D2016/144650

SSD 7664 – Stage 2 Horsley Drive Business Park

WaterNSW has reviewed the SSD and conducted a site inspection from the public cycle path, and provides the following comments:

DRAWING TITLE	
CONCEPT CIVIL WORKS PLAN SHEET 1	
DRAWING No	ISS
Co11492.11- DA41

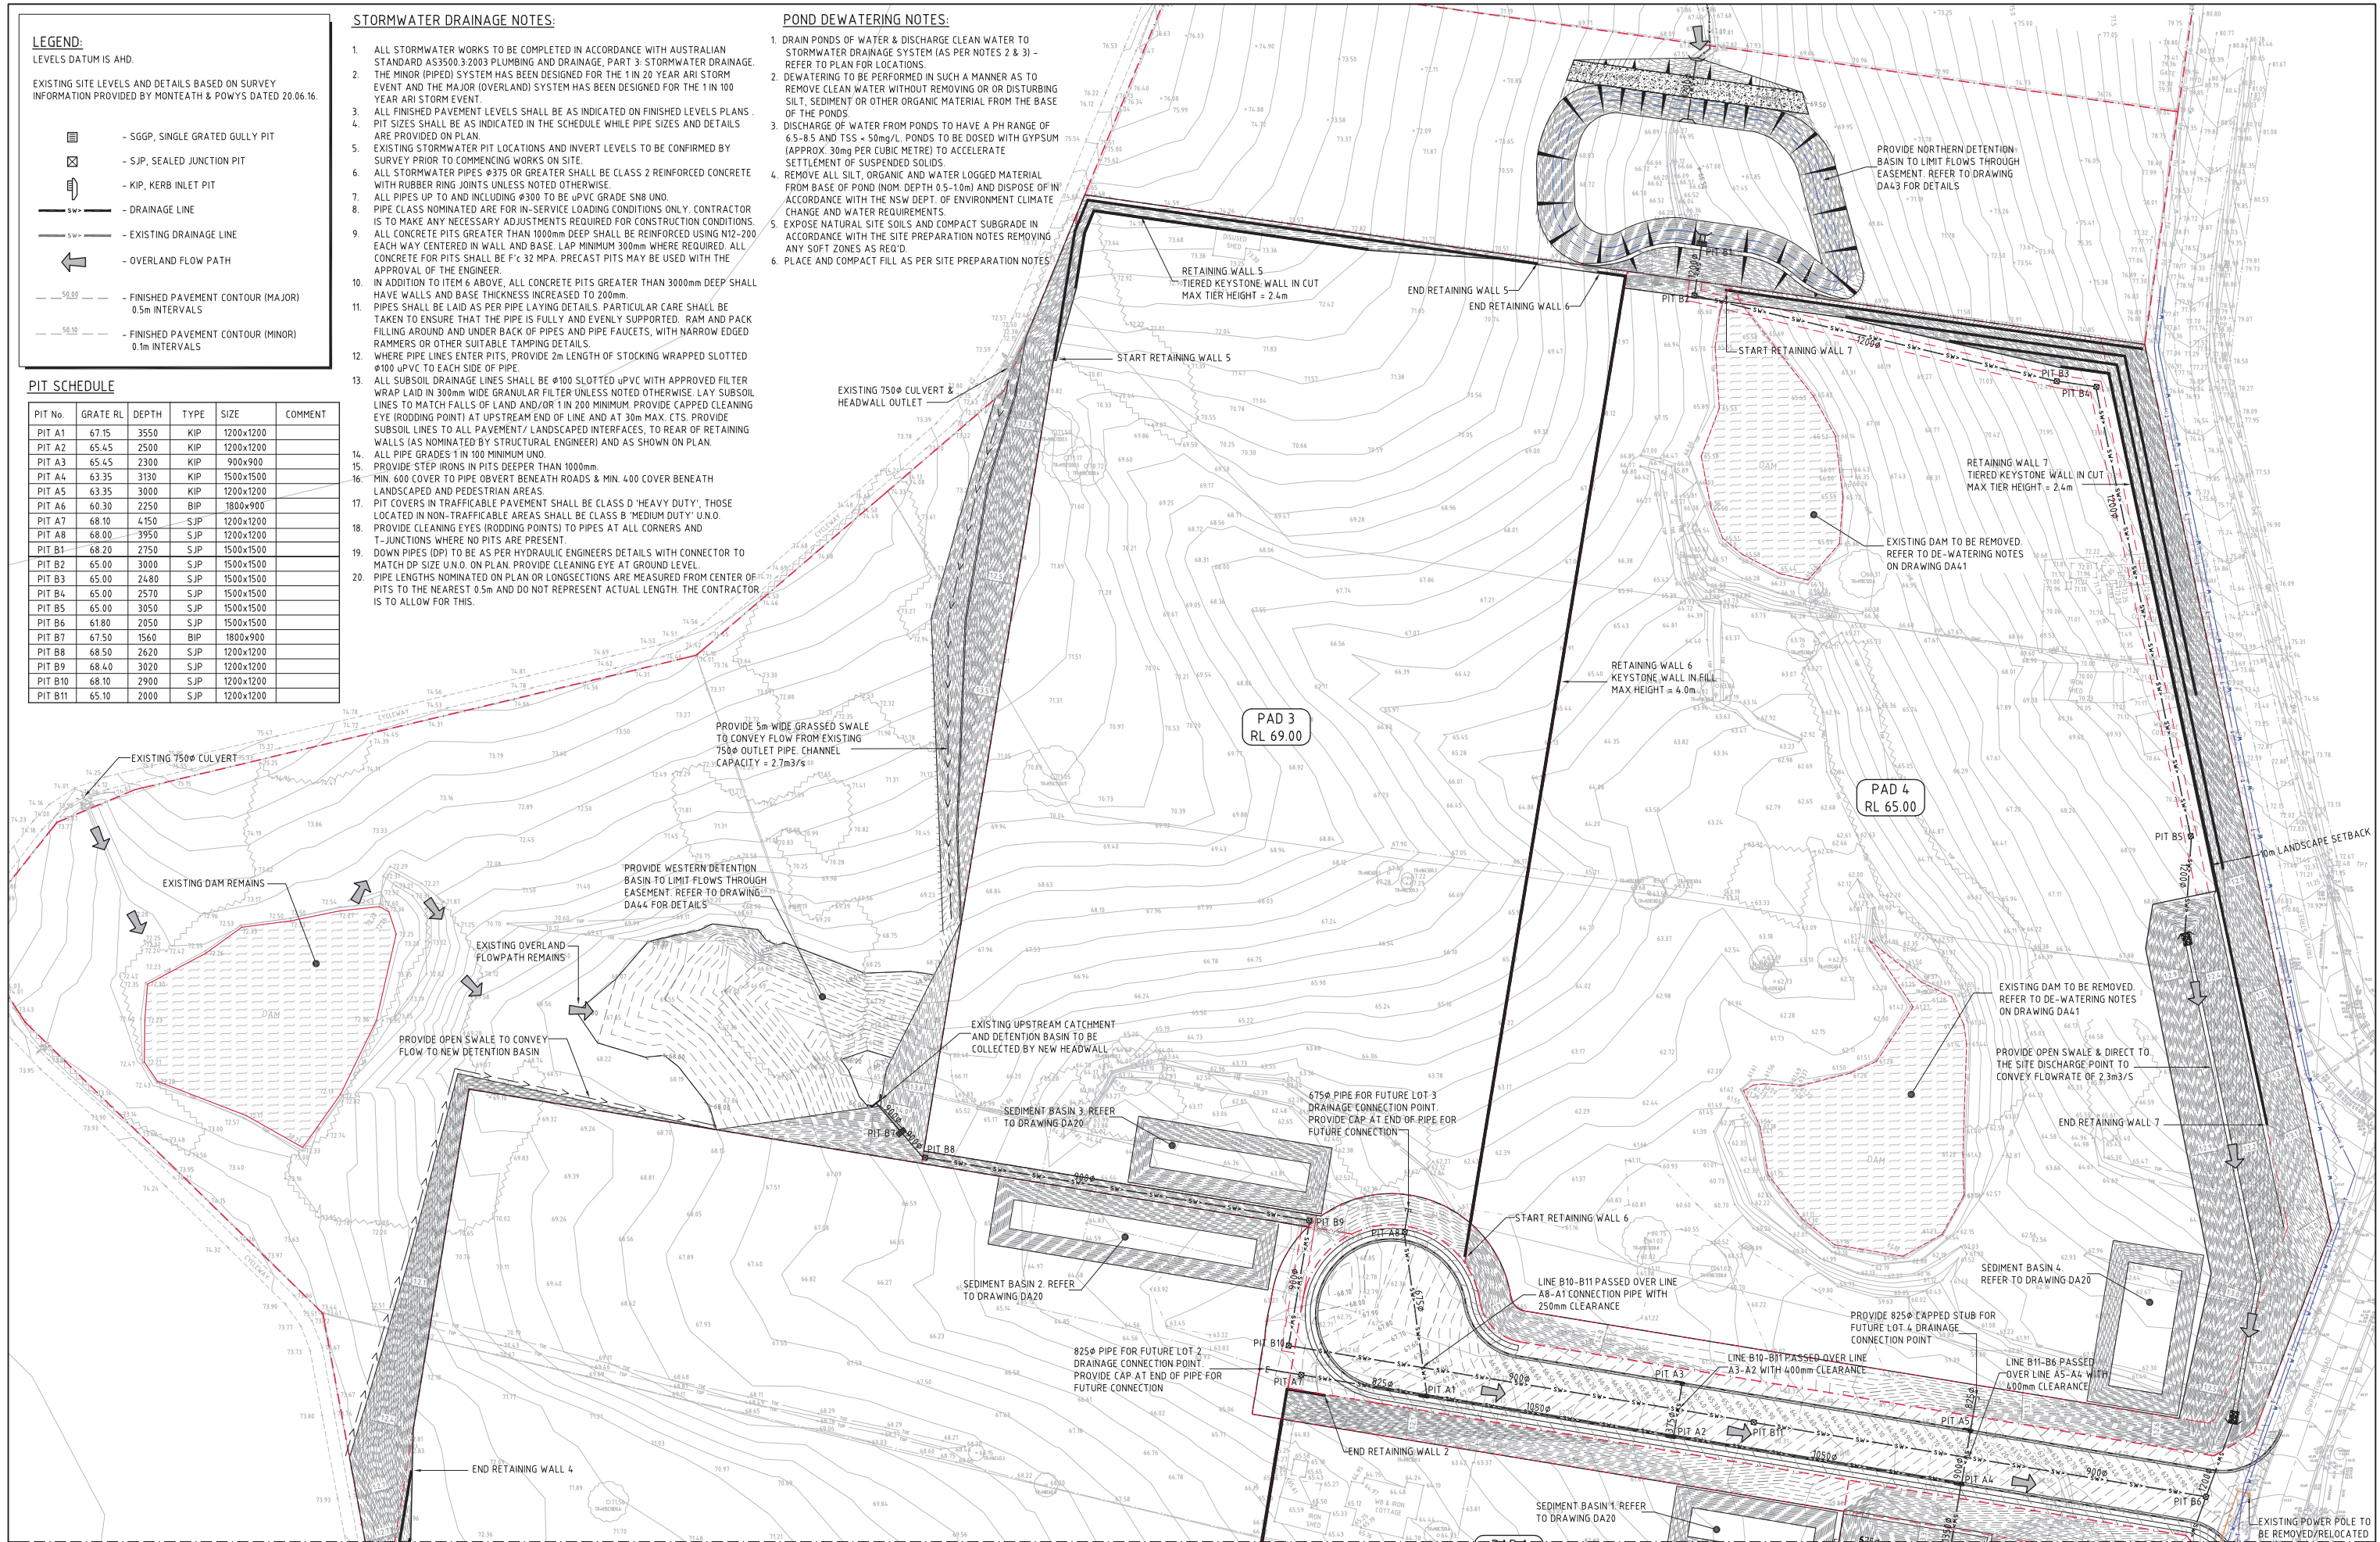
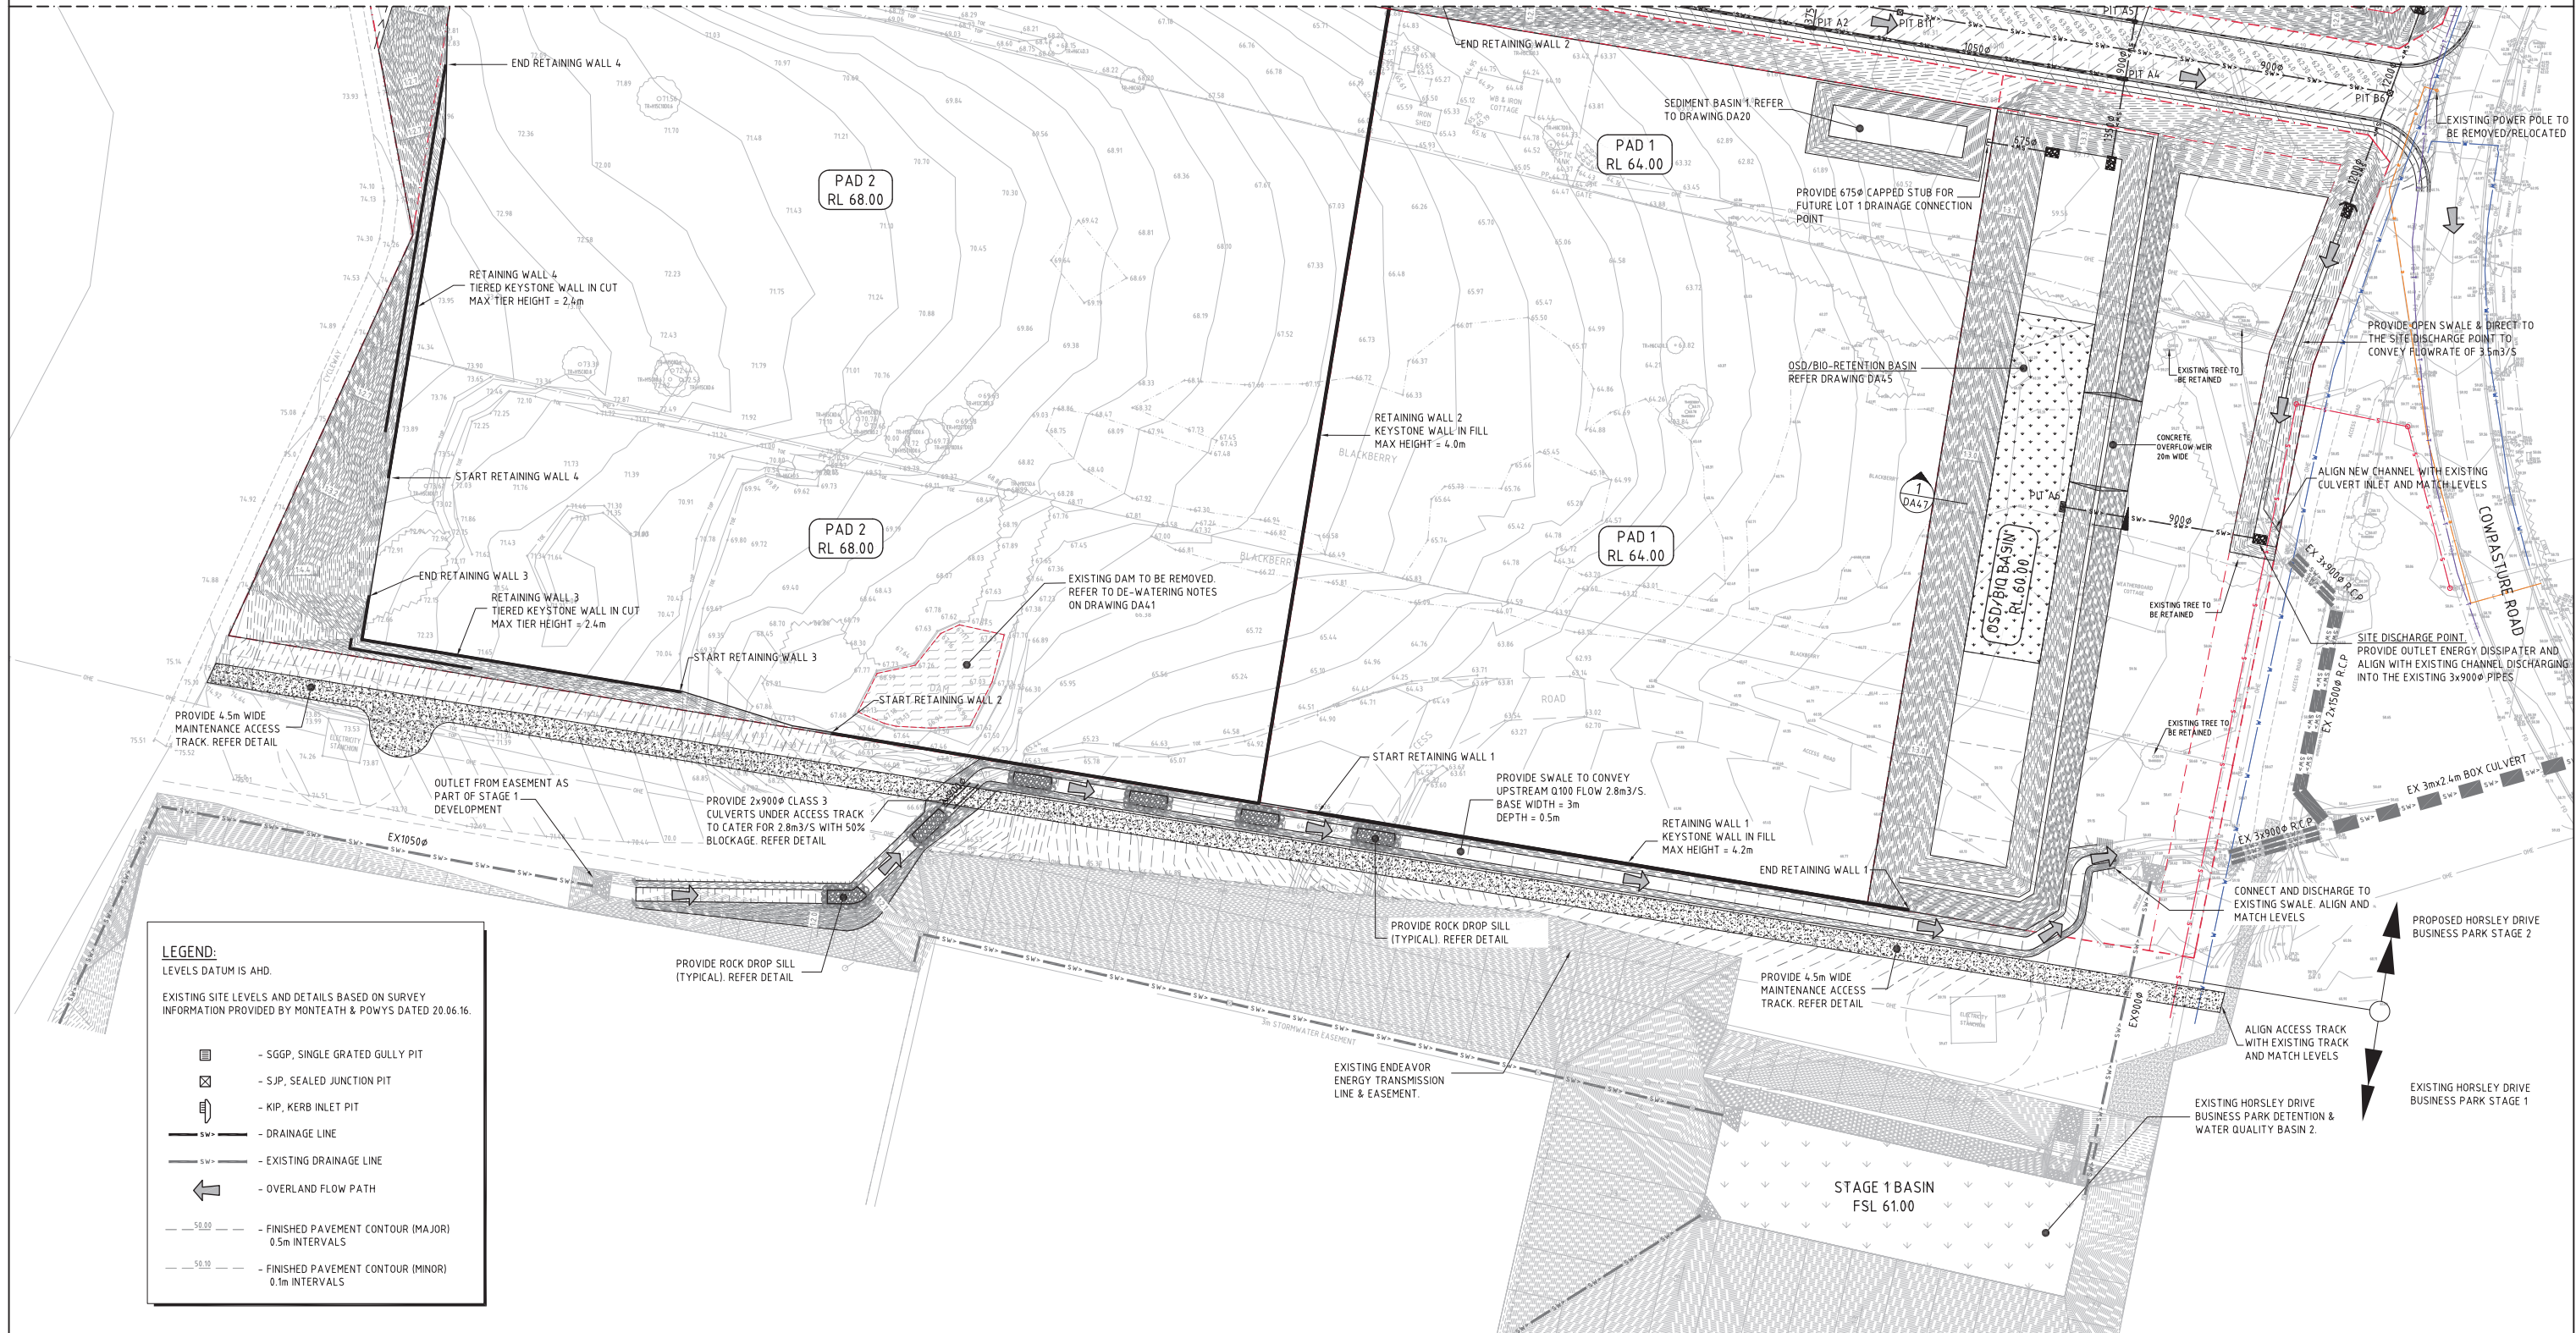
WaterNSW notes the Engineering Report (Costin Roe Consulting, Rev A, 2 December 2016) accounts for the catchment of the Upper Canal corridor, including the cycle path, as well as the catchment to the West of the corridor that drains to the East and on to the subject site.

- *The stormwater system for the site must be designed so as not to either impede upstream flows from the Upper Canal corridor or stormwater structures, nor result in increased flows onto WaterNSW land from the site.*

It is noted that extensive earthworks adjacent to the Upper Canal corridor, including significant cut and fill, are proposed as part of the application.

- *The development should not result in post-development site levels that cause an increase in stormwater flows onto the Upper Canal corridor, nor impede the pre-development levels of stormwater flowing off the corridor onto the subject site.*

- *WaterNSW should be provided with the details of the proposed earthworks, retaining walls or other construction along the boundary of the Upper Canal corridor before such works commence, and be advised in advance of any proposed construction activities close to the boundary.*
